Email: ecology@lancashire.gov.uk
Your ref: CONECO/3/2012/0578
Our ref: 03/12/0578/ASM/ASP/RS
Date: 19th September 2012

Planning Application No: **3/2012/0578**
Proposals: **Development of outdoor adventure centre**
Location: **Devil's Elbow land off Whalley Road (A671)**
District: **Ribble Valley**

Updated ecology comments following additional information and amendments

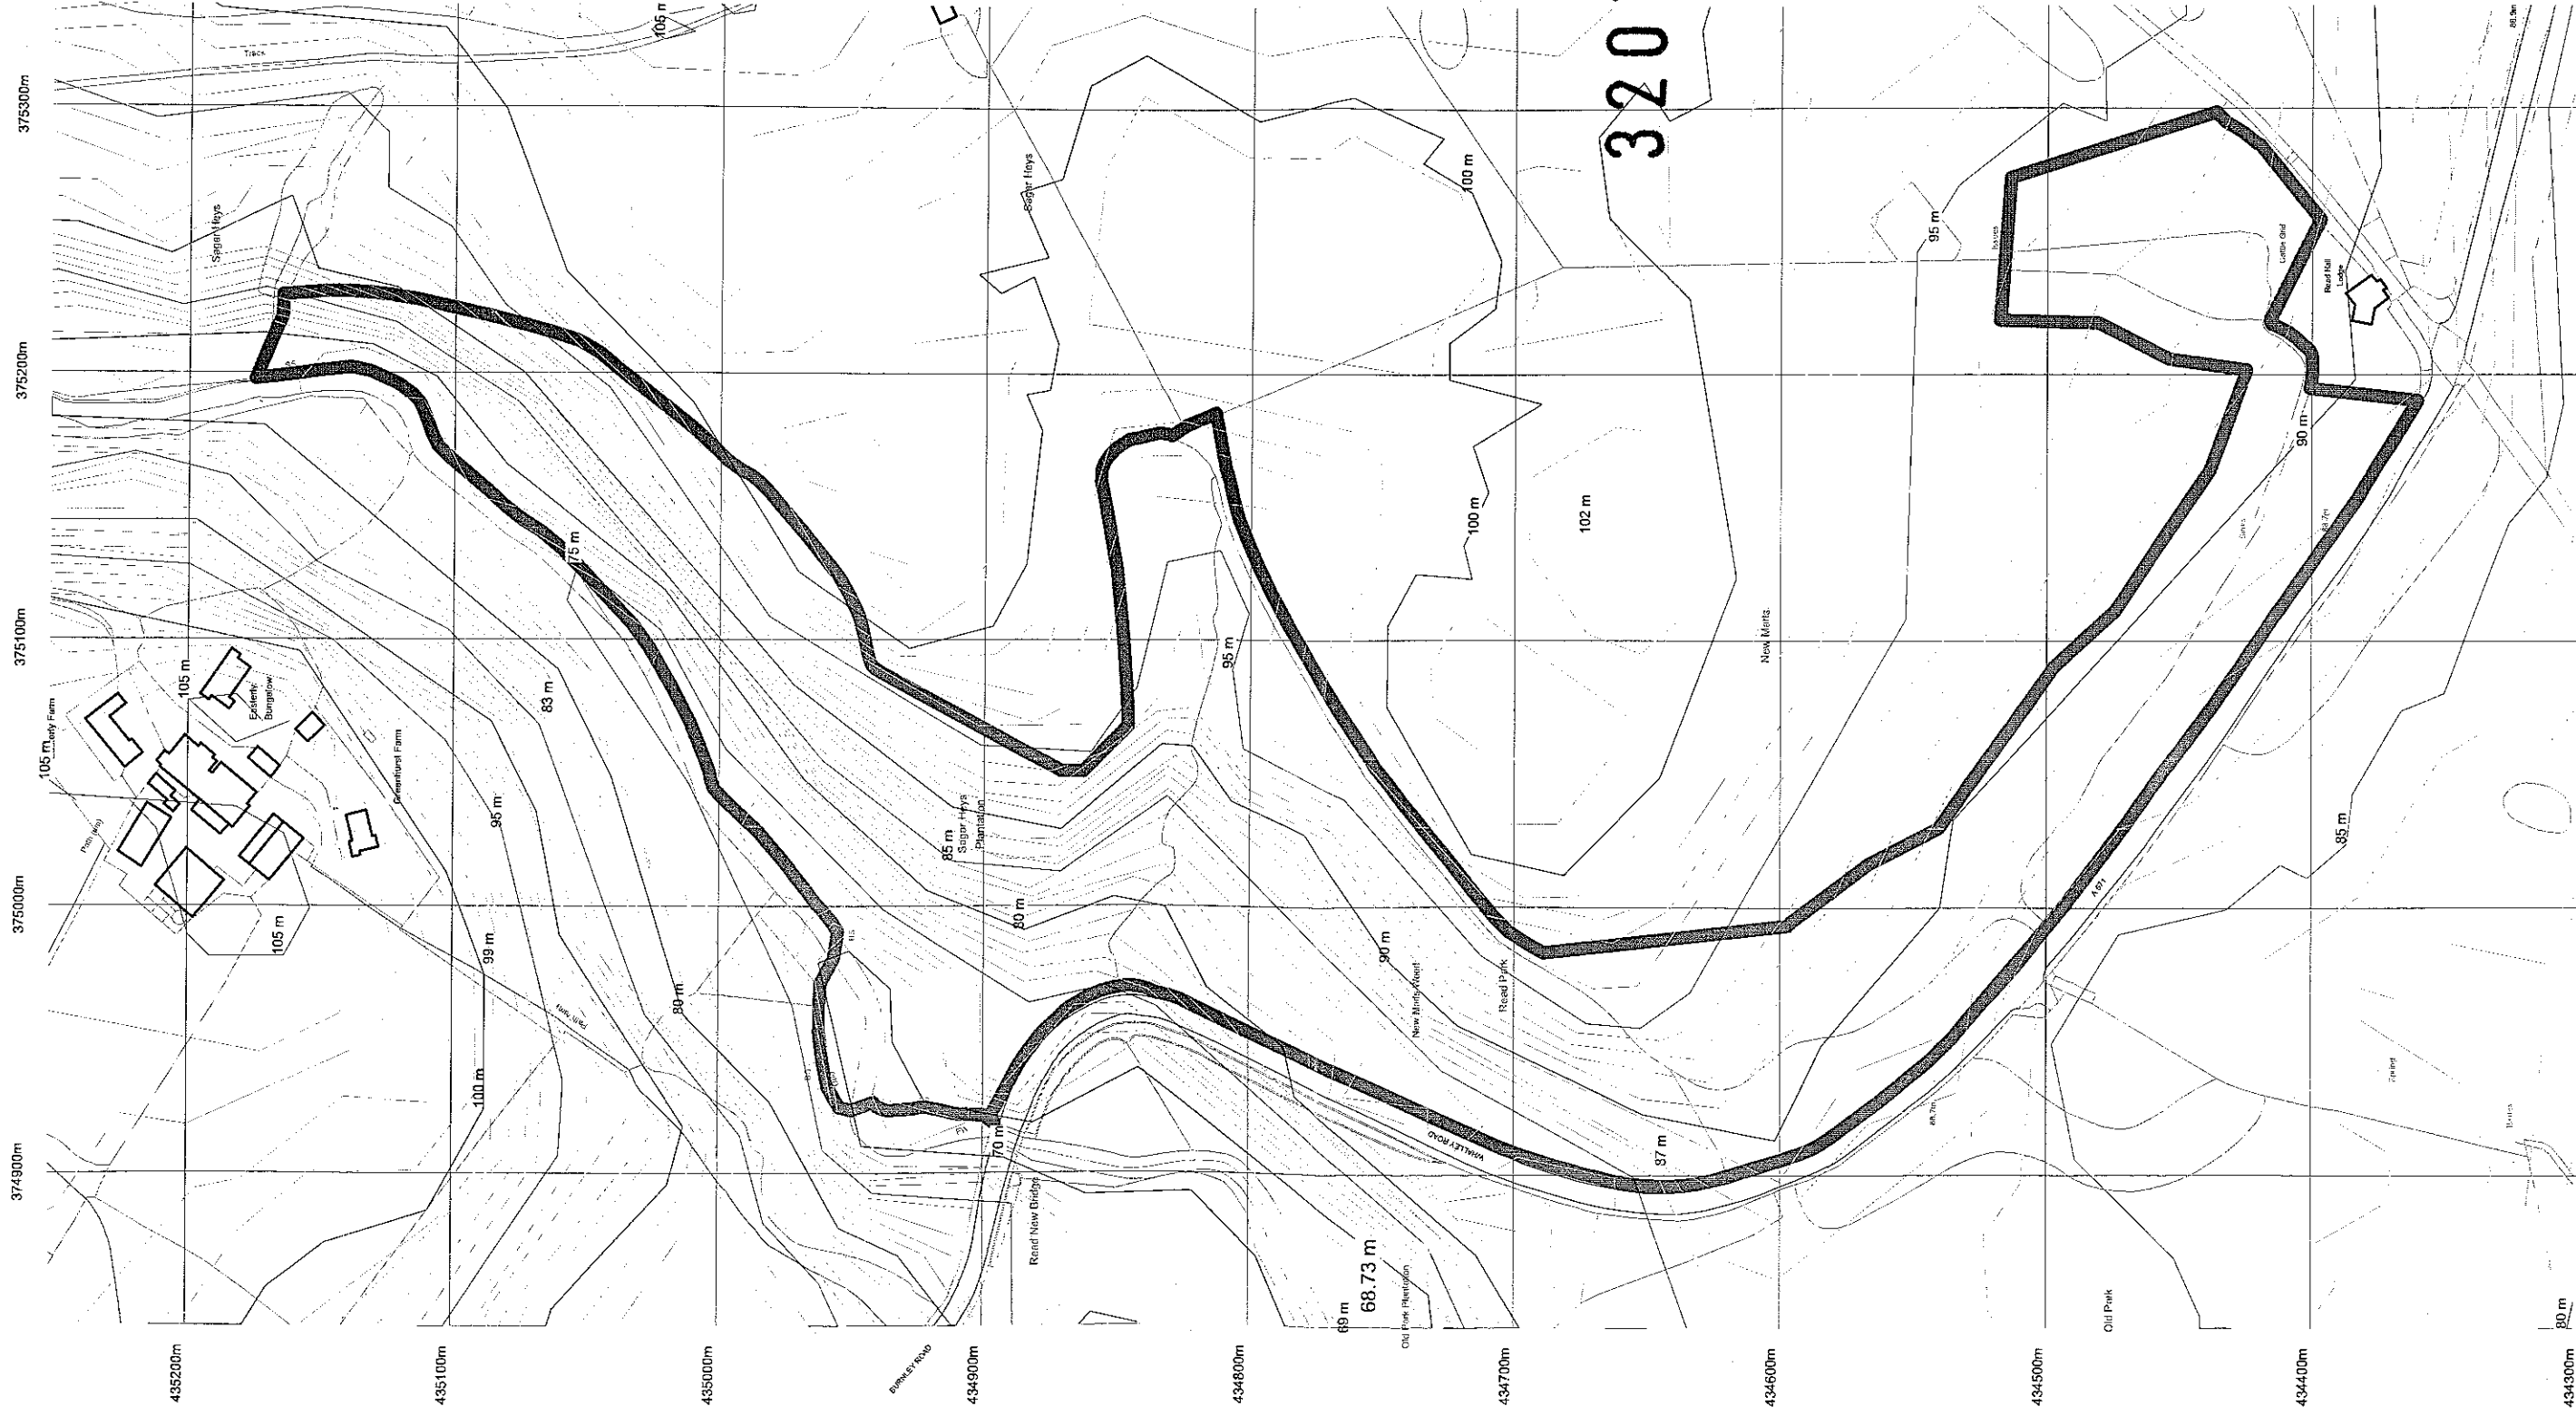
A Heronry occurs within the mixed plantation where the aerial walkway is proposed. The ecological survey undertaken on behalf of the applicant failed to detect the presence of the heronry. As a result, the ecological mitigation and compensation measures submitted with the application do not include any measures to avoid, mitigate or compensate for likely impacts on the heronry.

A site visit on 18th September revealed the presence of 6 Grey Heron nests within the area proposed to be used for the woodland high wire adventure course. Consultation with the local bird group has confirmed regular records of a heronry in this location with 6 active nests being recorded in 2011. This number of active nests is considered to be a "significant population of a scarce Lancashire breeding bird" (updated BHS guideline Av3).

In order to avoid any confusion over the approved scheme, I recommend that, prior to determination, the submitted layout plan should be withdrawn and replaced by a plan demonstrating that the education/interpretation trails within the ancient woodland will be removed from the proposals and showing indicative fencing proposals to prevent access to the ancient woodland as well as any measure to address the above issues in relation to the heronry.
